**WEST SUSSEX COUNTY COUNCIL  
PLANNING SERVICES CONSULTATION**

**SUBJECT: LU/184/17/PL - 1 No. dwelling (resubmission following LU/31/14/).**

**Land adjacent to 75A, Clun Road, Littlehampton, West Sussex, BN17 7ED**

Block plan

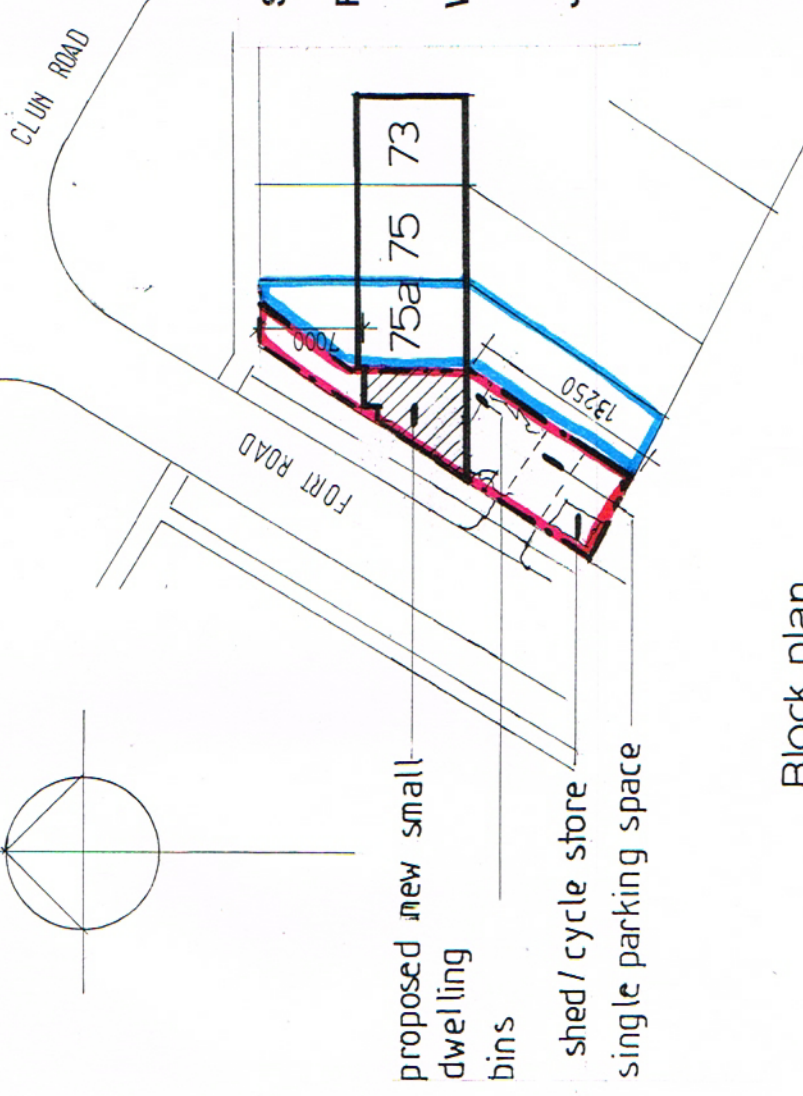
The current scheme is a resubmission of that approved scheme, with vehicle access and single off-street parking space off an existing point from Fort Road. From an inspection of the latest plans and documents there does not appear to be any change in the previously commented on highways aspects of the scheme.

No part of the development shall be first occupied until the car parking has been constructed in accordance with the approved site plan. These spaces shall thereafter be retained at all times for their designated purpose.

No part of the development shall be first occupied until covered and secure cycle parking spaces have been provided in accordance with the approved site plan.
